From: Contact Centre (CRM) <contact@ribblevalley.gov.uk>
Sent: 24 June 2026 21:37
To: Planning
Subject: Planning Application Comments - 3/2026/0295 FS-Case-850867373

Planning Application Reference No.: 3/2026/0295

Address of Development: Brian Holden Memorial Playing Field Mardale Road Longridge PR3 3EU

Comments: Representation: Proposed 3G Football Pitch Development

# PITCH LAYOUT

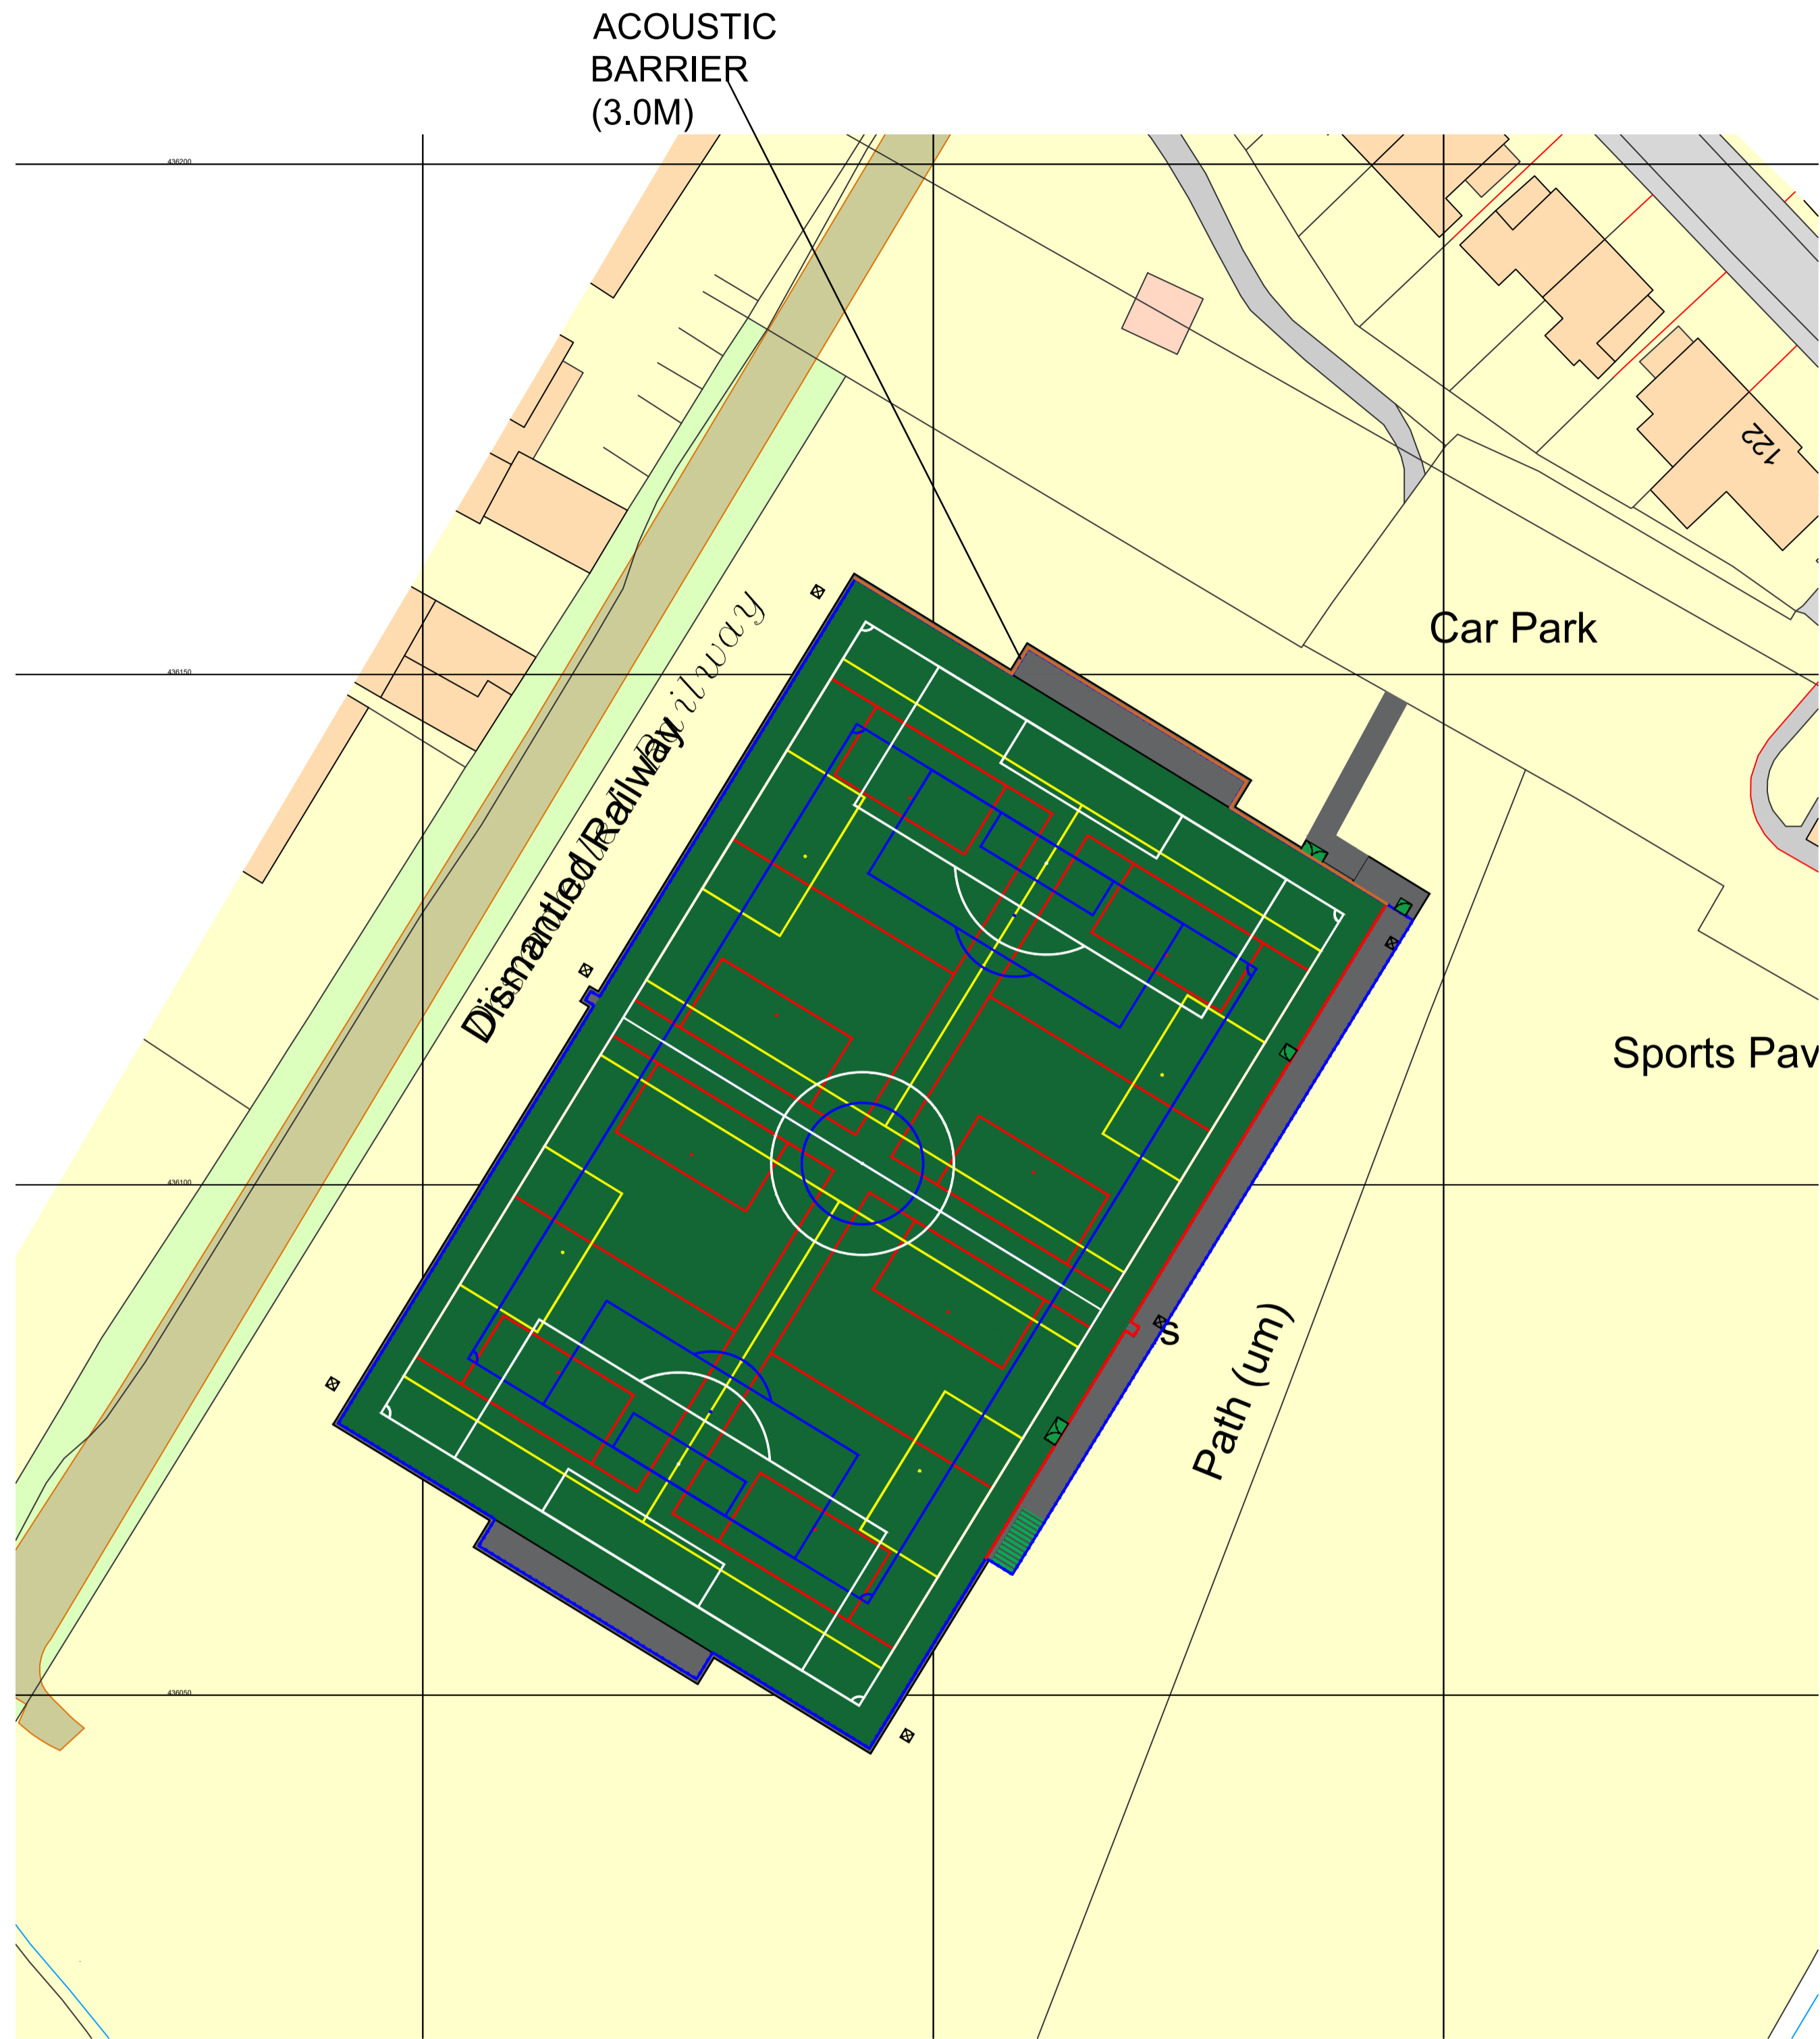
Site Layout Relocate the 3G pitch towards the lower part of the field to increase the separation distance between the pitch, floodlighting, spectator activity and nearby homes.

1. A suitable alternative access route away from the Mardale estate, including consideration of access via Alston Grange or the existing access/path near Shay Lane and AVJ Design, if it can be properly assessed and upgraded.
2. Relocation of the 3G pitch to the lower part of the field to maximise distance from nearby homes and reduce the impact of floodlighting and noise.
3. Installation of speed-reduction measures on Mardale Road and Hacking Drive to protect residents, pedestrians and children using the area.
4. Provision of sufficient free on-site parking to prevent displacement of visitor parking onto residential streets.
5. Protection of the green area on Hacking Drive through suitable fencing or barriers, to reduce risk to children playing nearby.
